**20221019-ABP-314501**

**REF.: 314501**  
**APP: Monaghan County Council**  
**FOR: South Dublin Street and Backlands Regeneration Project. The proposed development covers an area of approximately 2.72 hectares and comprises urban regeneration and public realm proposals.**  
**SITE: Properties at 7- 13 Dublin Street, the rear of 1-9 The Diamond and 1-26 Dublin Street, the Courthouse car park, Lower Courthouse car park, Castle Road, and N54 Macartan (Broad) Road, Monaghan town**

An Taisce wishes to make the following observation in relation to the Environmental Impact Assessment Report (EIAR).

EXISTING BUILDINGS TO BE DEMOLISHED
Dublin Street No. 08, 09, 10 and 11.

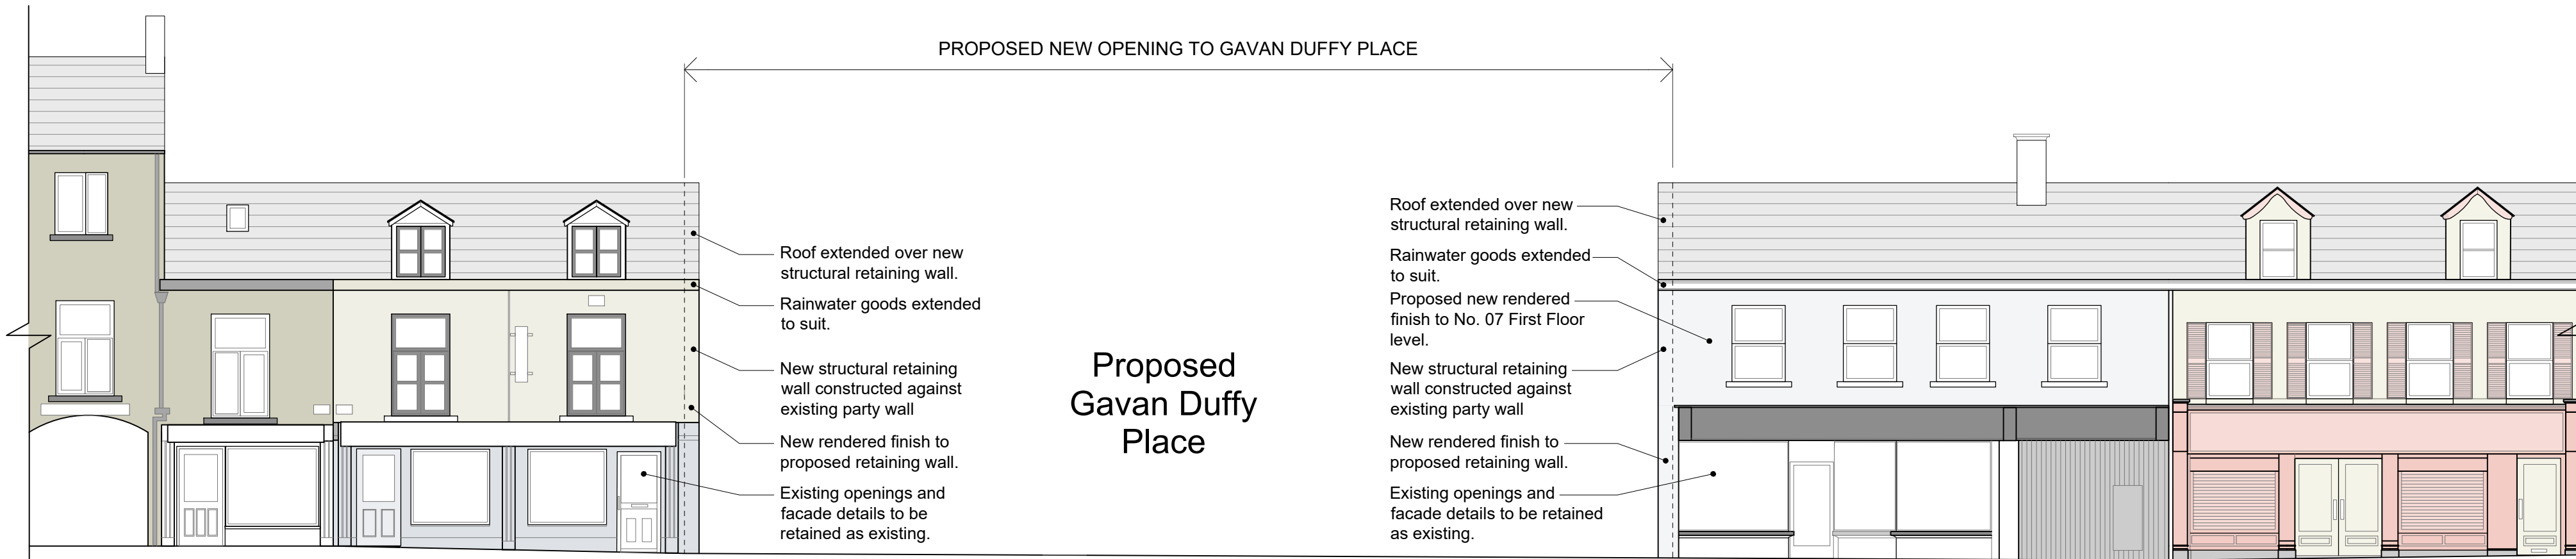
*Section 2.6.3, Alternative Designs and Layouts* fails to consider alternative design options for the removal of the four buildings on Dublin Street. No. 10 has a 19<sup>th</sup> Century carriage arch and, therefore, the provision of pedestrian and cycle access does not require the removal of any buildings and vehicle access can be accommodated from the rear.

The development proposal which includes demolishing four 19<sup>th</sup> Century, or potentially earlier, buildings and creating a new road is entirely antithetical to the character of the ACA.
